Application for removal or variation of a condition following grant of  
planning permission. Town and Country Planning Act 1990.  
Planning (Listed Buildings and Conservation Areas) Act 1990

Demolition of existing bungalow and associated ancillary outbuildings and the construction of one detached dwelling and garage at Homefields Basil Road West Dereham King's Lynn Norfolk

12/01720/F

DRAWING TITLE  
Plans & Elevations Pitch Roof

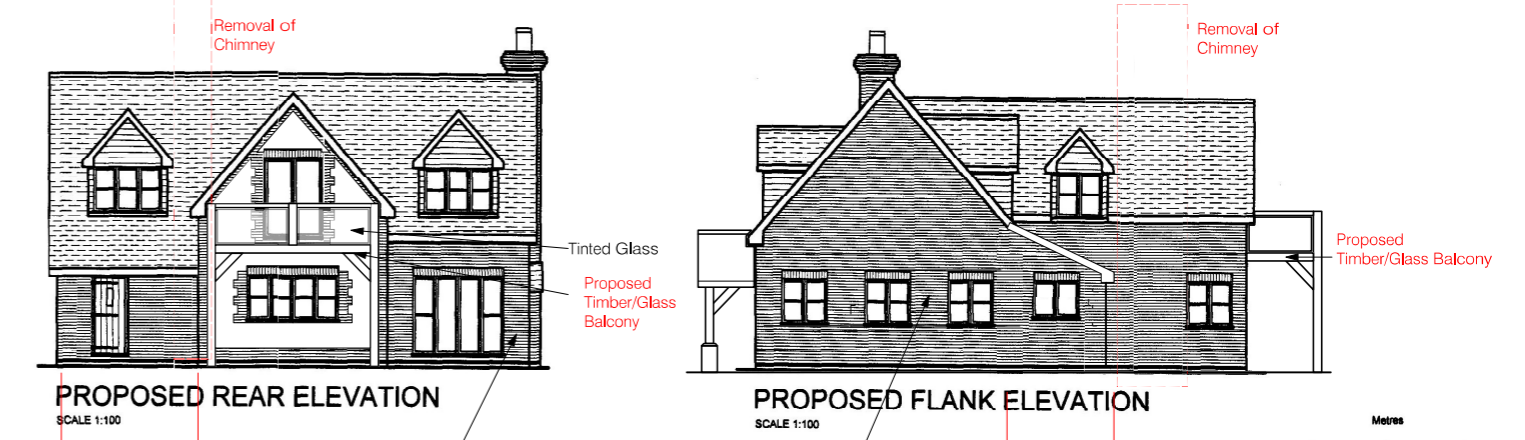
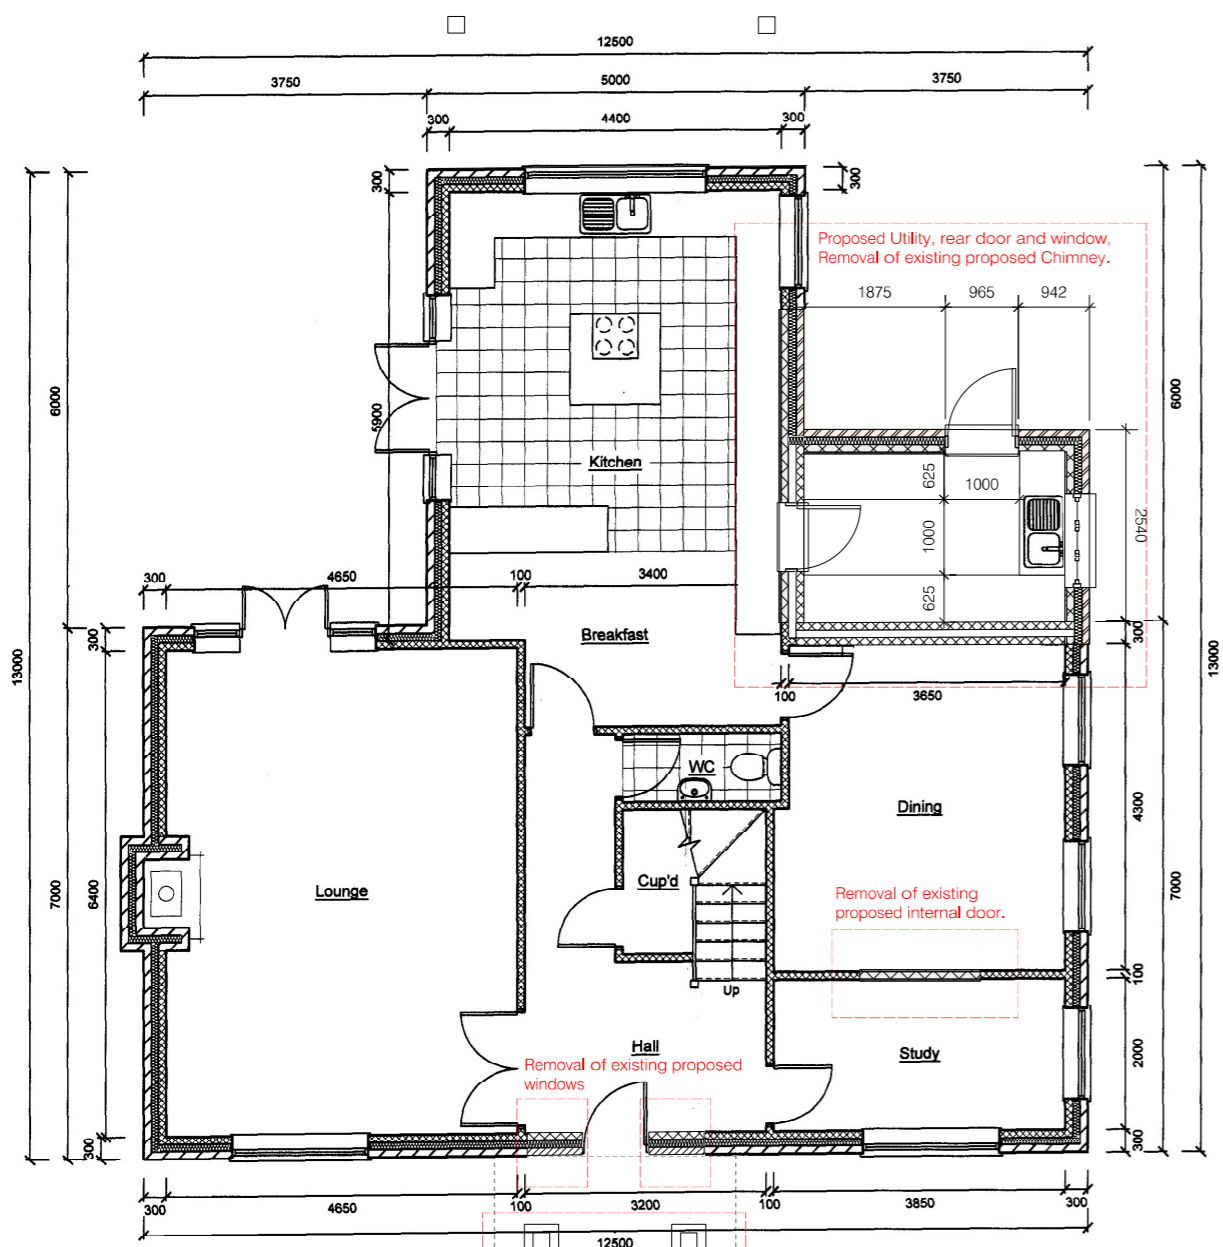
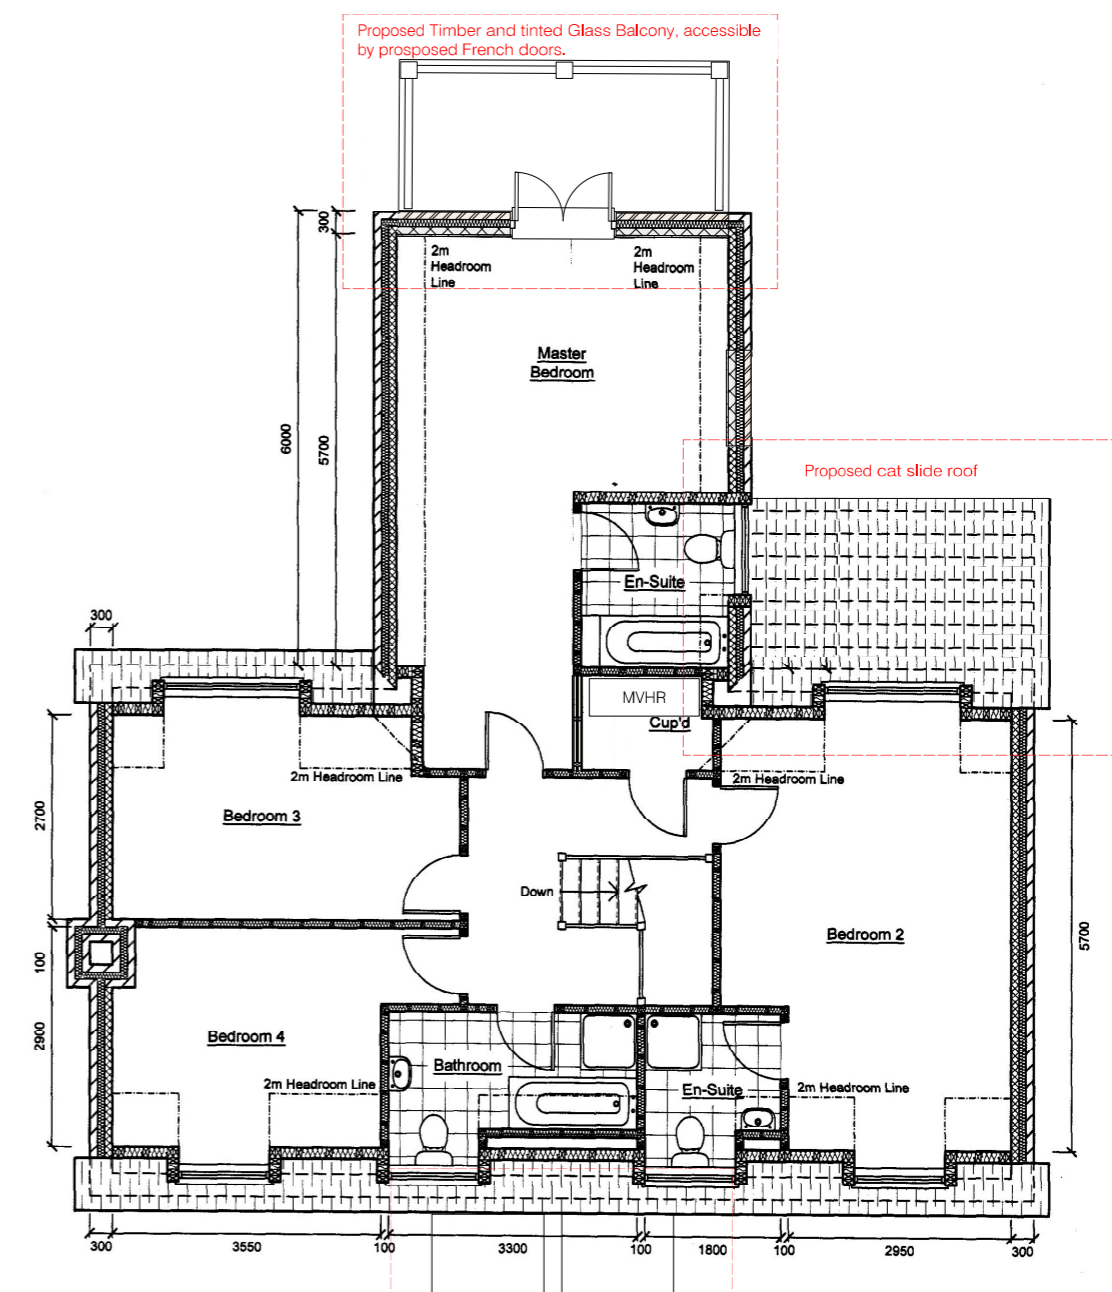
The changes to the design are listed below:

Proposed Utility, rear door and window,  
Proposed Timber/Glass Balcony  
Proposed Timber Porch  
Removal of Chimney,  
Removal of internal door.  
Removal of existing proposed windows at the main entrance.

Replace approved drawing no. ABD/1047/04 dated 11th June 2012 with 2141-PL-01-A-Plans and Elevations
